Planning Inspectorate ref. EN070005

**ESSO PETROLEUM COMPANY LIMITED - DCO APPLICATION FOR THE SOUTHAMPTON TO LONDON PIPELINE PROJECT:**

**DEADLINE 5 RESPONSE BY SPELTHORNE BOROUGH COUNCIL**

Illustration 3.1: Access around Ashford Station (see Appendix A for legend)

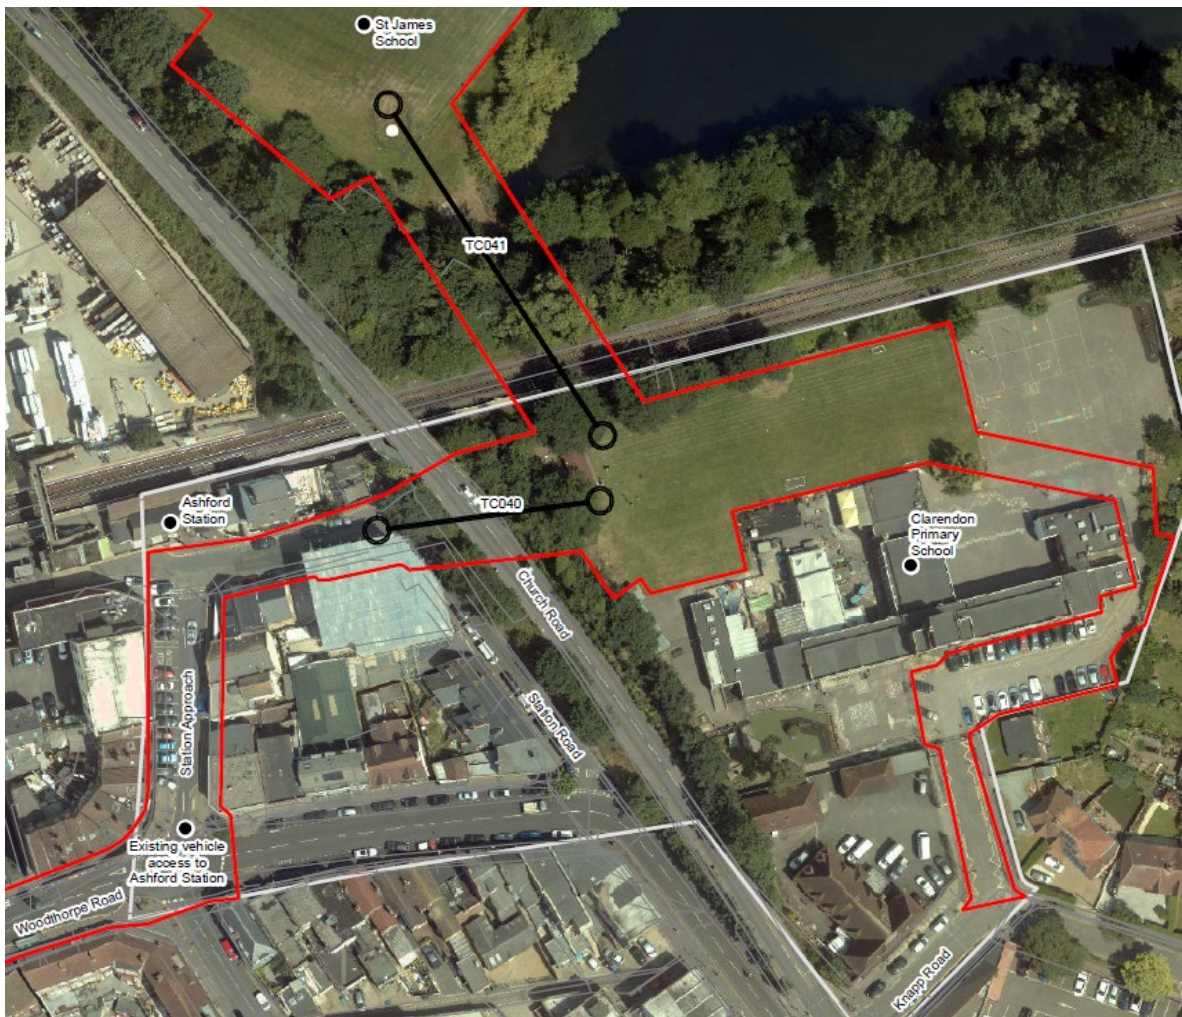
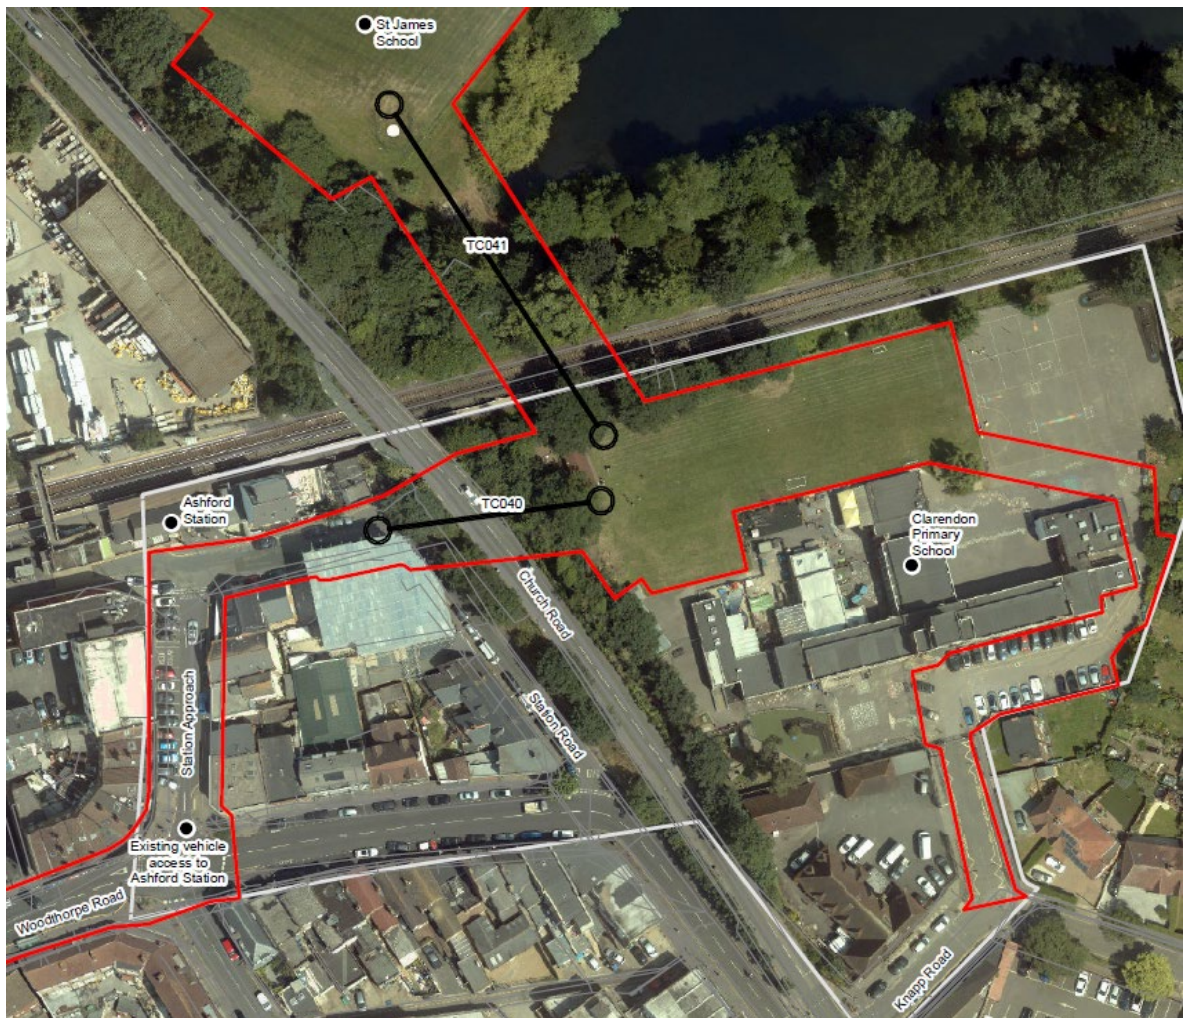
4.2 SBC identified neighbouring Clarendon primary school and Ashford town centre and station approach as a ‘hotspot’ requiring site-specific attention. It is understood that an SSP for the area around Ashford station will be provided at Examination Deadline 5 and that this will seek to address the concerns the Council highlighted in respect of Clarendon Primary School in paras. 9-12-9.19 of its LIR (REP1-021).

4.3 From discussions between the Council and the Applicant it is understood that Esso has agreed with the County Education Authority and Clarendon Primary School’s headteacher that construction works would take place and be reinstated within school summer holidays in the western extremity of the school grounds with no work undertaken in term-time. It is ultimately for the school and the

Illustration 3.2: Trenchless crossing from Station Road to Clarendon School

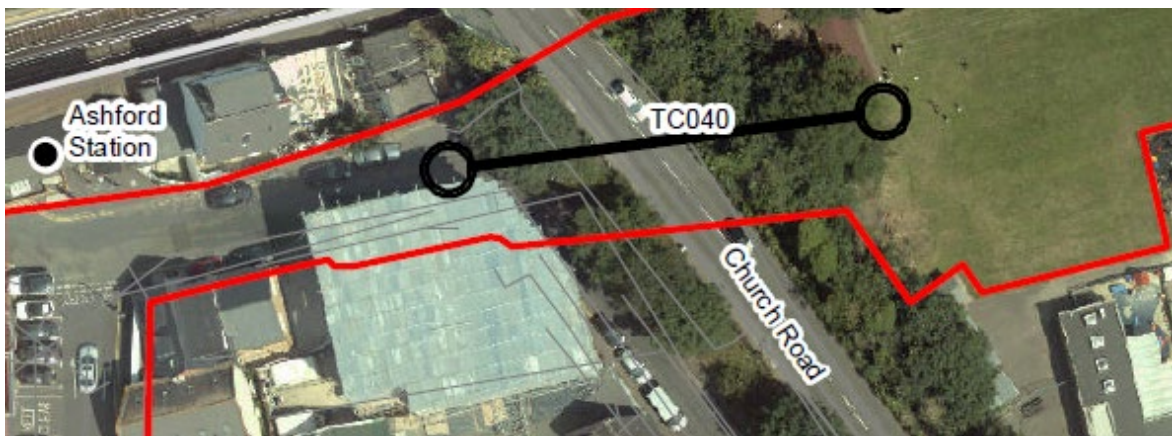
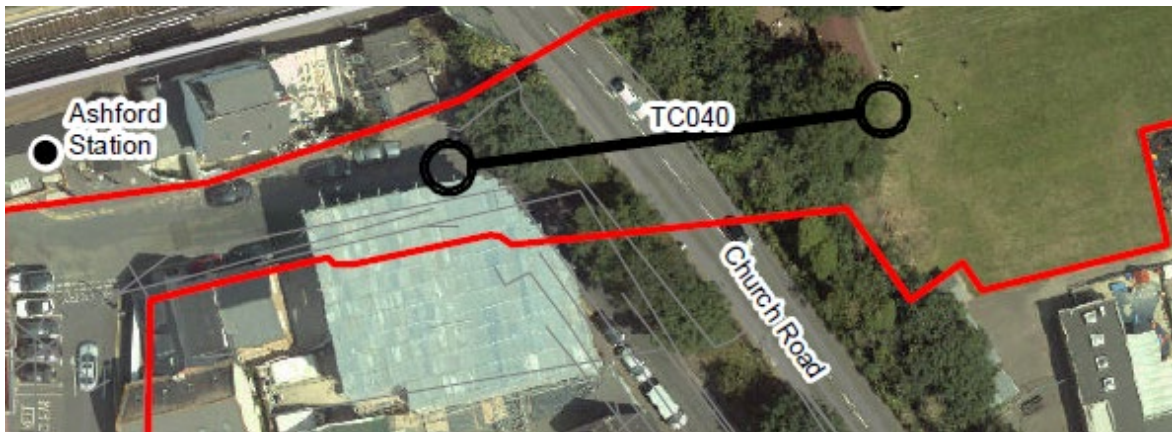
4.4 The Council remains concerned to protect the amenity of residents of Village Way whose homes back on to Clarendon Primary School. Completion of trenchless crossings during the narrow working window of a school holiday implies extended working hours that could significantly affect residential amenity, particularly in summer when householders quite reasonably wish to have their windows open. It is noted with concern that these properties have not been identified in Esso's *Appendix 13.3 Noise and Vibration Technical Note Addendum* submitted at Deadline 4 (REP4-017).
